Ribble Valley Borough Council
Development Control

Application no: 3/2020/0602

Address: Holden Clough Nursery,

Proposal: Creation of additional dining space

**Holden Clough Nursery
Existing Parking Plan
(Not to scale)**

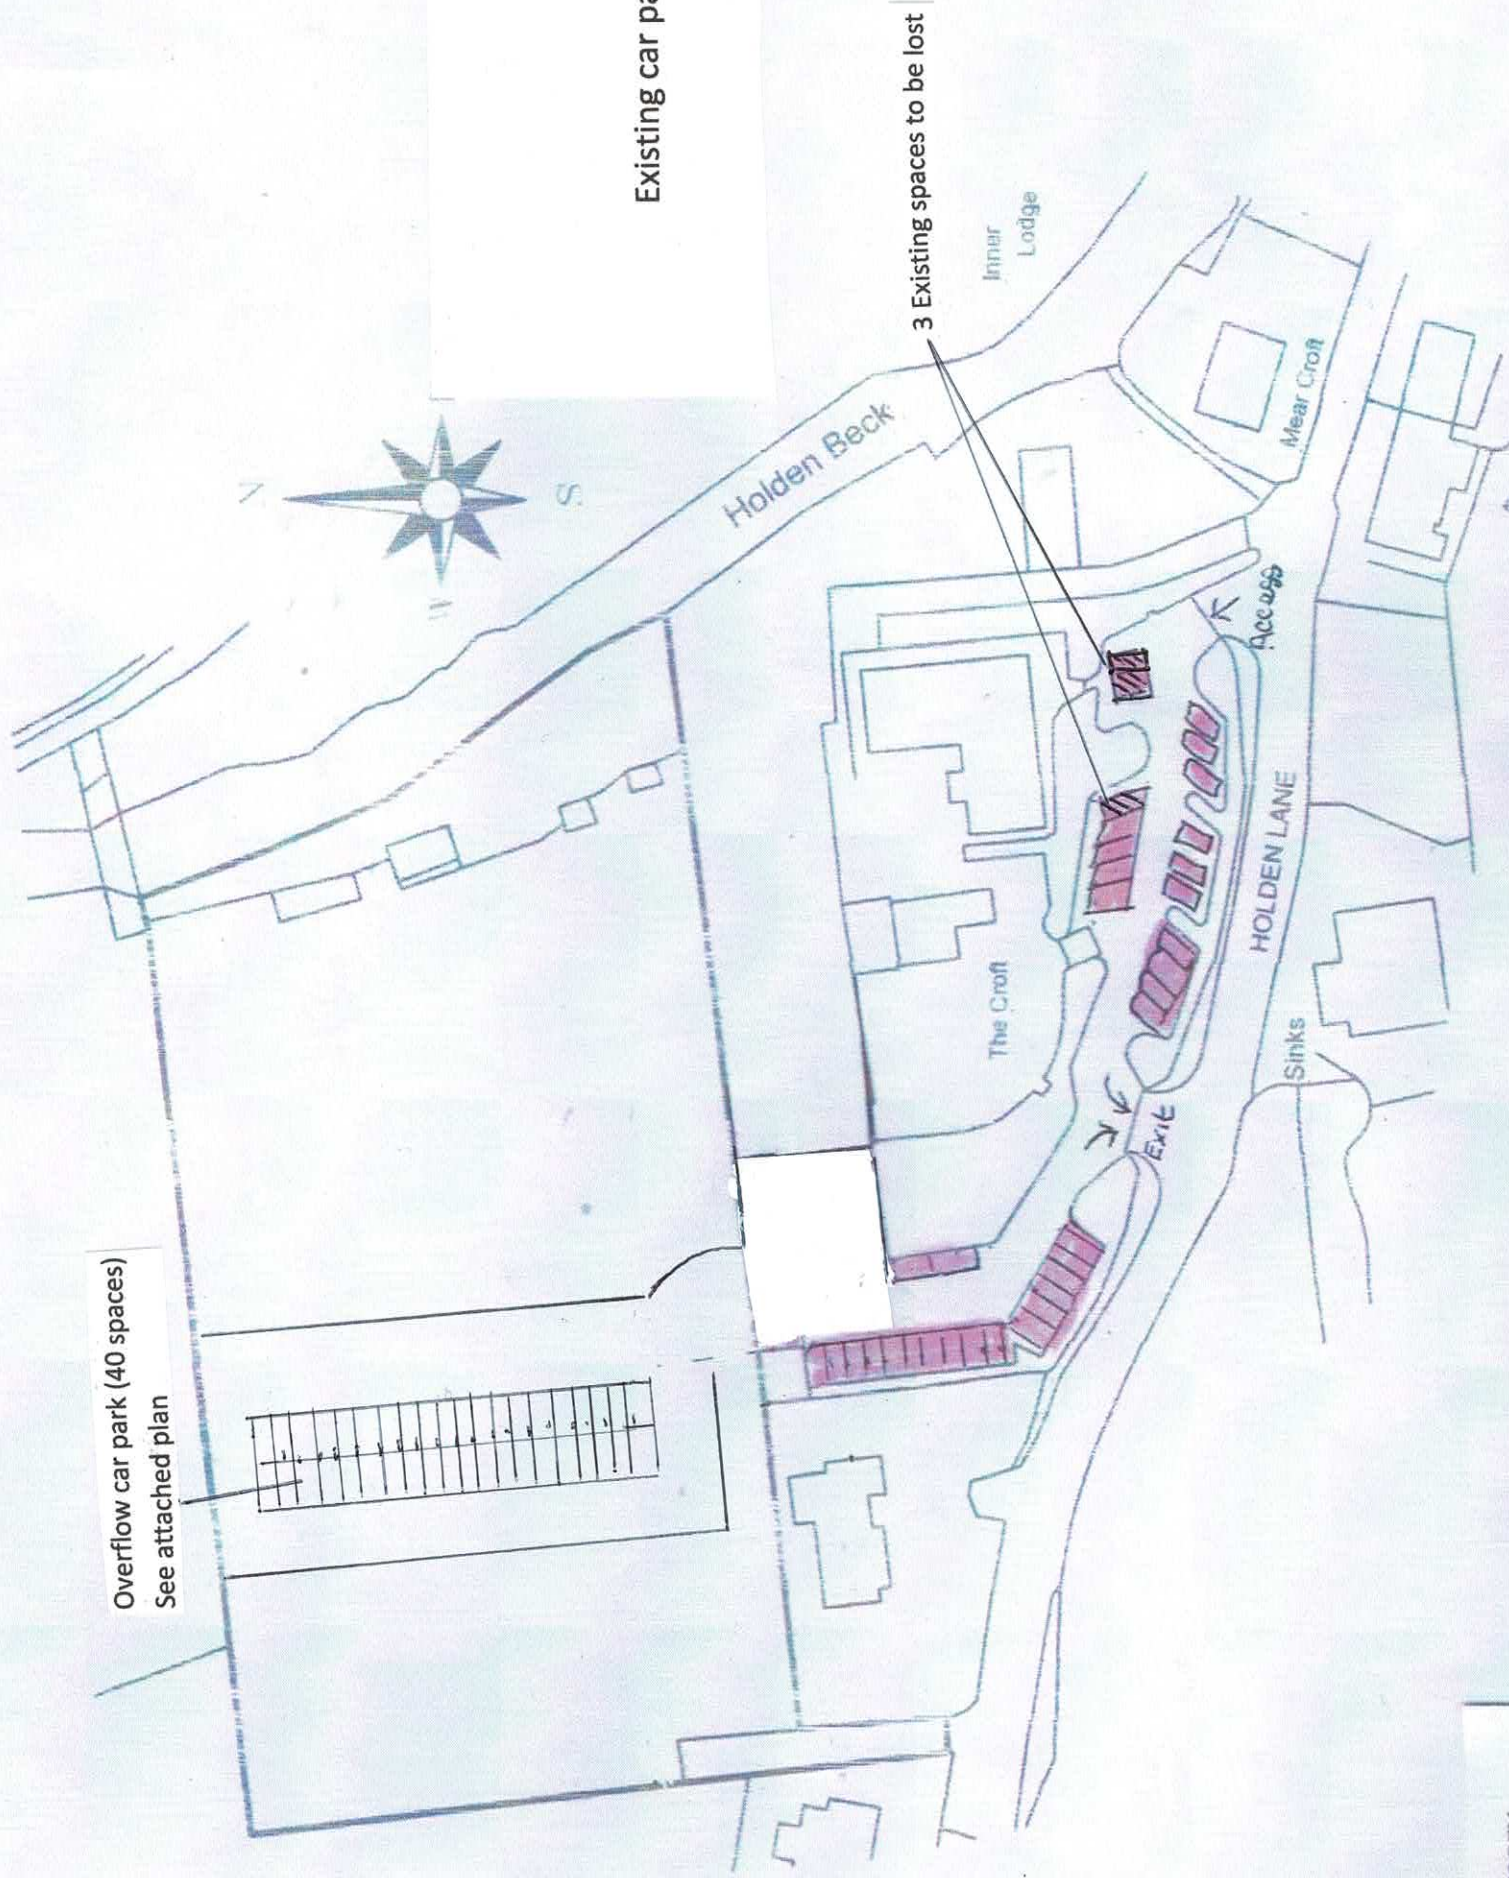
The proposal is to increase the size of the dining area and provide a deli sales area together with increased storage facilities. The proposal will increase its current café floor area from 426 sqm to 780 sqm. The parking provision for the site is currently 71 spaces, however the proposal will see the loss of 3 spaces leaving 68 spaces available. Notwithstanding the existing uses on the site and the proposed deli retail element, the proposed increase in the floor area will require a parking provision of 98 parking spaces.

Enquiries with the LPA suggest that a planning condition restricting the number of covers to the existing level could not be reasonably enforced. This potential uncontrolled increase in the number of covers together with the inadequate parking provision for the proposed development as submitted would place an additional burden on the local highway network in terms of additional vehicles visiting the site and increase the likelihood of vehicles parking on the adjacent highway to the detriment of highway safety and residential amenity. In view of these concerns and unless there is a reasonable and enforceable limit to the number of dining

covers that can be placed on the café element of the proposed development restricting it to the current levels I would have to recommend that the application be refused.
